**Re: Office/Warehouse for McClintic RDM, 9700 Trumbull Ave SE,  
Traffic Circulation Layout  
Architect's dated 5-12-14 (L20-D051)**

Based upon the information provided in your submittal received 5-13-14, the above referenced plan cannot be approved for Building Permit until zoning signs off on TCL and the following comments are addressed:

SITE PLAN
SCALE: 1" = 20'-0"

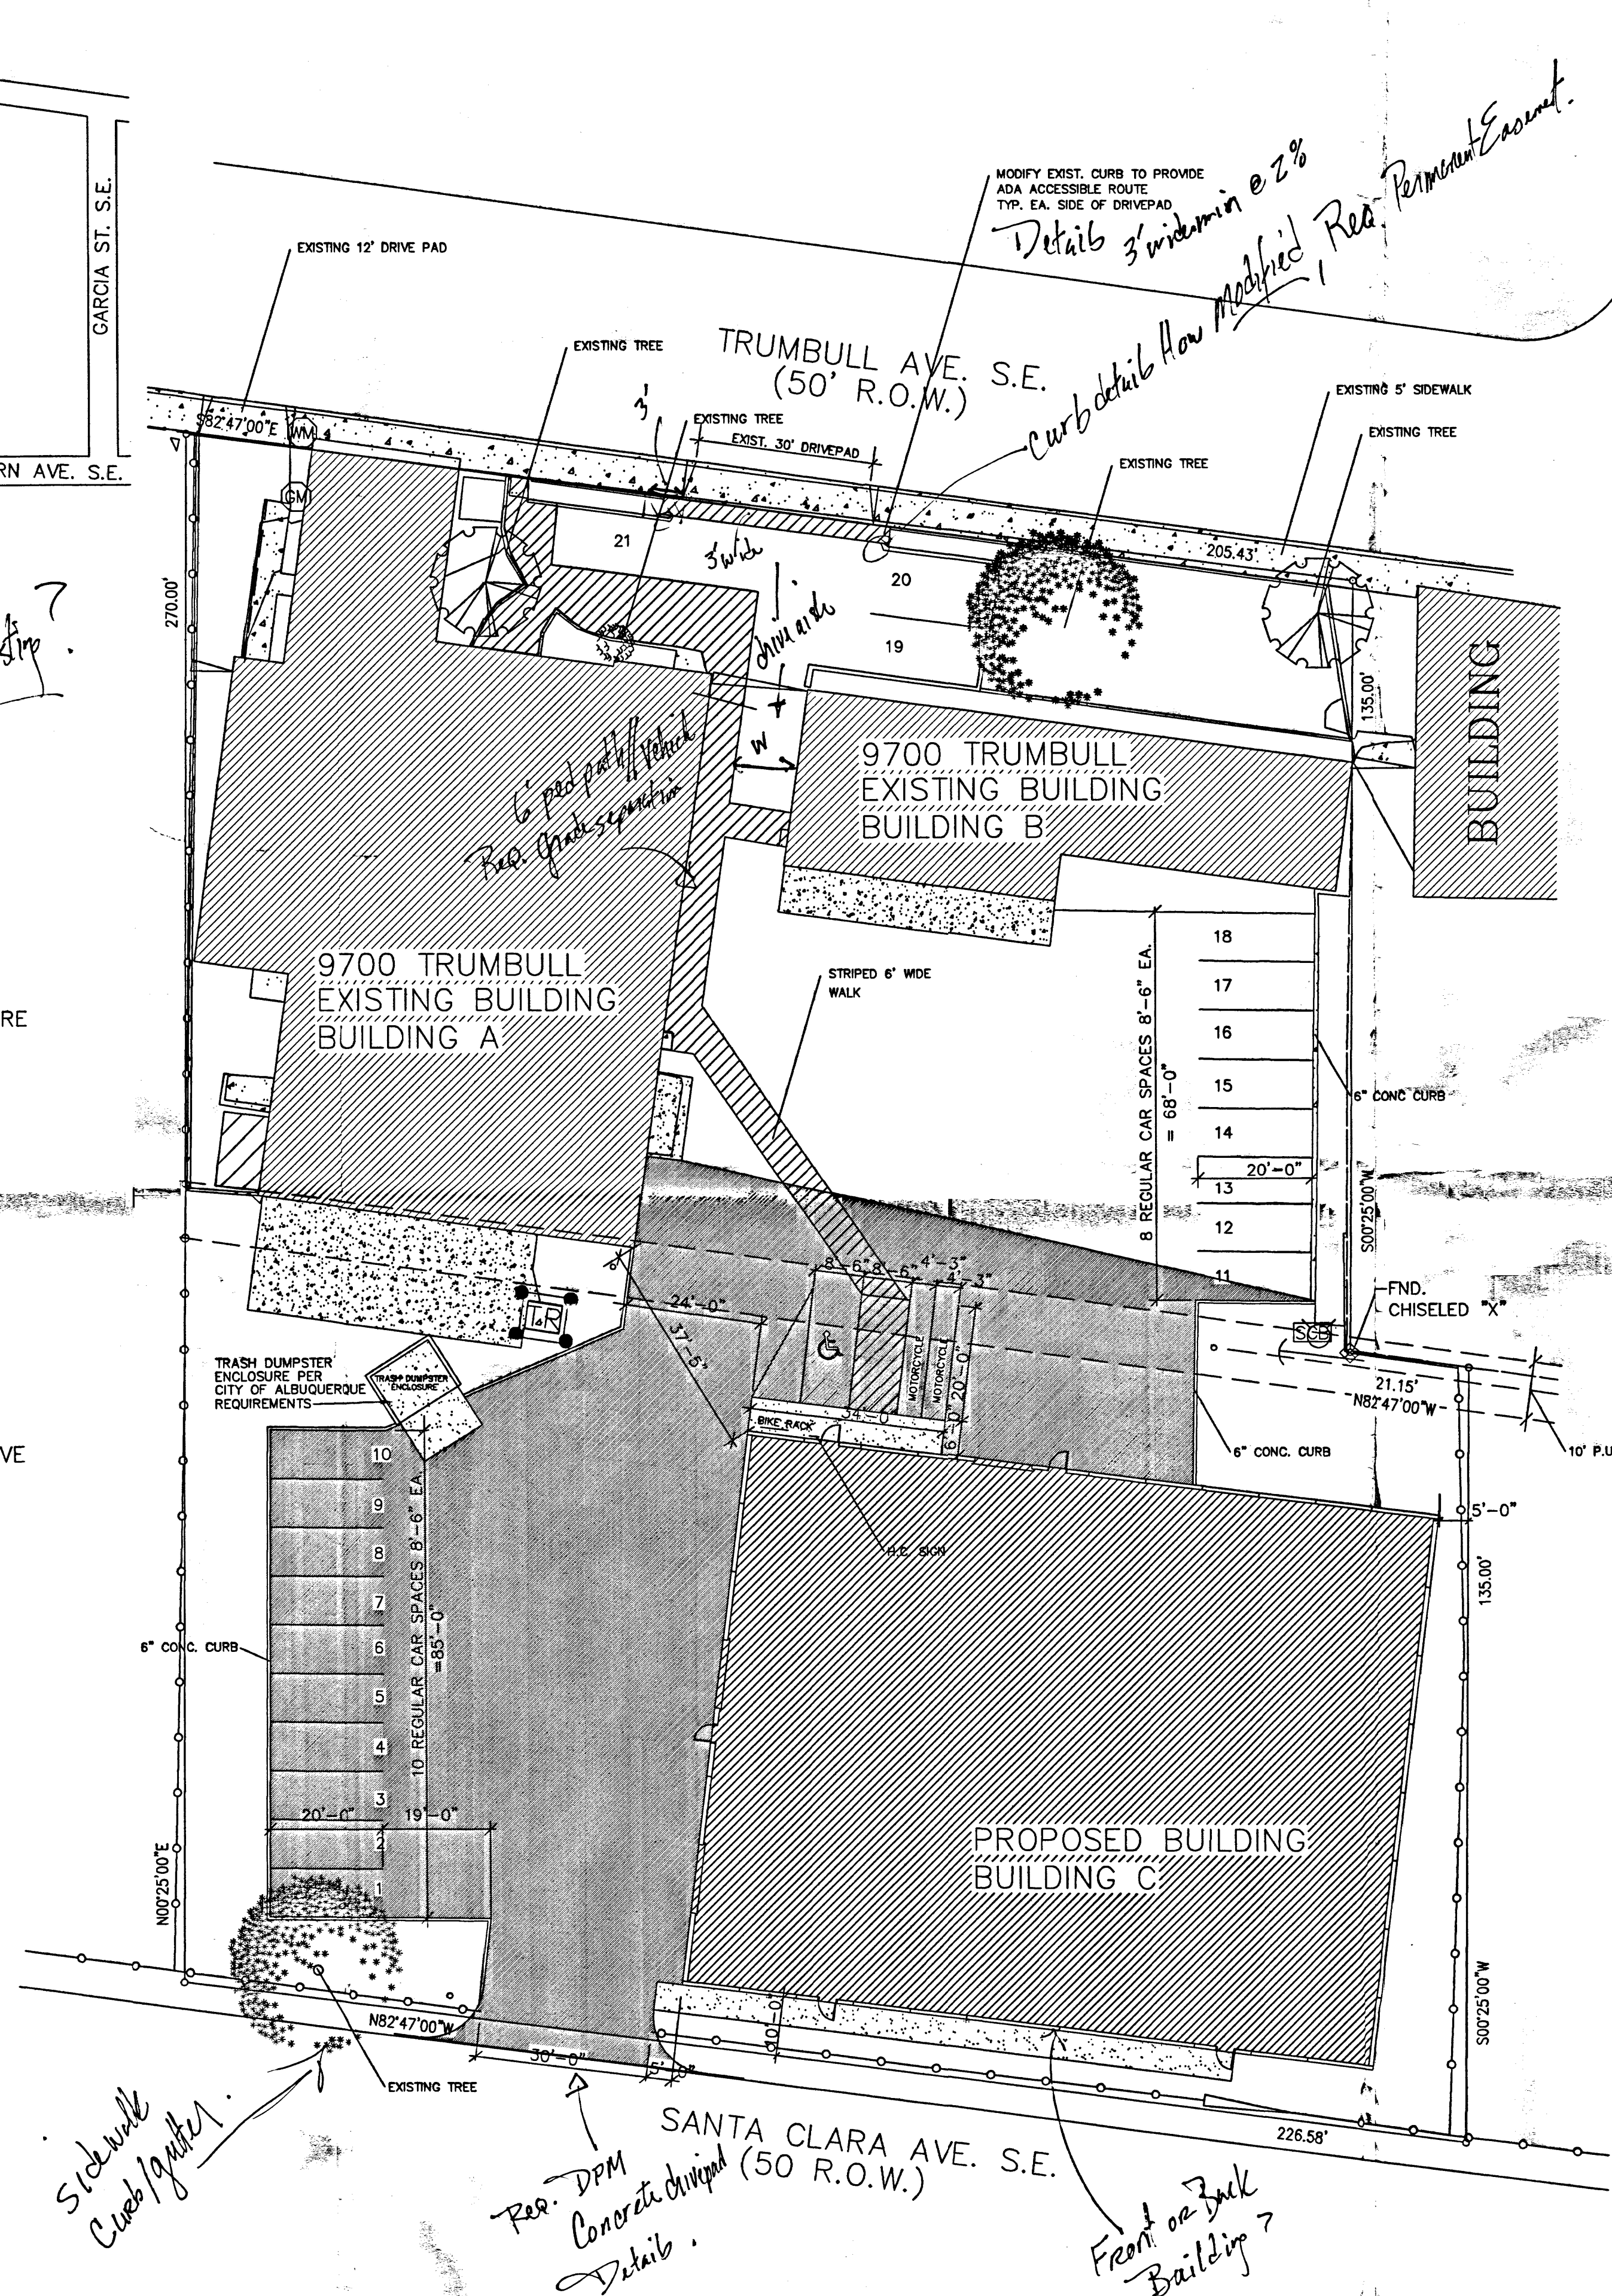
1. Please show a vicinity map.
2. The development of this site must be in compliance with current DPM and ADA standards and regulations.
3. Please refer to all applicable city standards for proposed infrastructure.

4. Please include, label and define all easements within site.
5. Per the DPM, a 6 ft. wide ADA accessible pedestrian pathway is required from the public sidewalk to the building entrances. Please clearly show this pathway and provide details.

6. Per the DPM, a 6 ft. wide ADA accessible pedestrian pathway is required from the HC parking stall access aisles to the building entrances.
7. Define width of the existing sidewalk on Trumbull.

8. List the width of the existing drivepad on Trumbull.
9. Is existing drivepad ADA compliant? Provide details. All drivepads crossing city sidewalks must provide ADA access per DPM and East Gateway SDP (5.6.1.C.4.c, p5-46)

10. Provide details or refer to the appropriate city standard for proposed 30 ft wide drivepad on Santa Clara.
11. Sidewalk, curb and gutter are required along the frontage of Santa Clara Ave. Label and provide appropriate city standards for infrastructure improvements.

12. Please place frontage sidewalk at the property line, not the back of curb.
13. Show a detail of the wheelchair ramps located at the proposed driveway, or refer to the appropriate city standard.

14. Please ensure all ramps are ADA compliant
15. Is landscaping required by zoning? If so, please provide landscaping plan with next submittal. Per the *Development Process Manual*, Chapter 23,

Section 7, Part B.6, curbing should be used to separate landscaping from parking areas and pedestrian ways as well as providing a physical perimeter for harvesting water. This must be clearly shown on the TCL.

16. Please add the following note: "Landscaping and signing will not interfere with clear sight requirements. Therefore, signs, walls, trees, and shrubbery between 3 and 8 feet tall (as measured from the gutter pan) will not be acceptable in this area."
17. Per DPM, any concrete infrastructure along COA right-of-way fronting property must be in good condition. Broken or cracked concrete must be removed and replaced to the nearest control joint.
18. Please note, as of June 2, 2014, a PDF version of TCL must be provided with each submission.
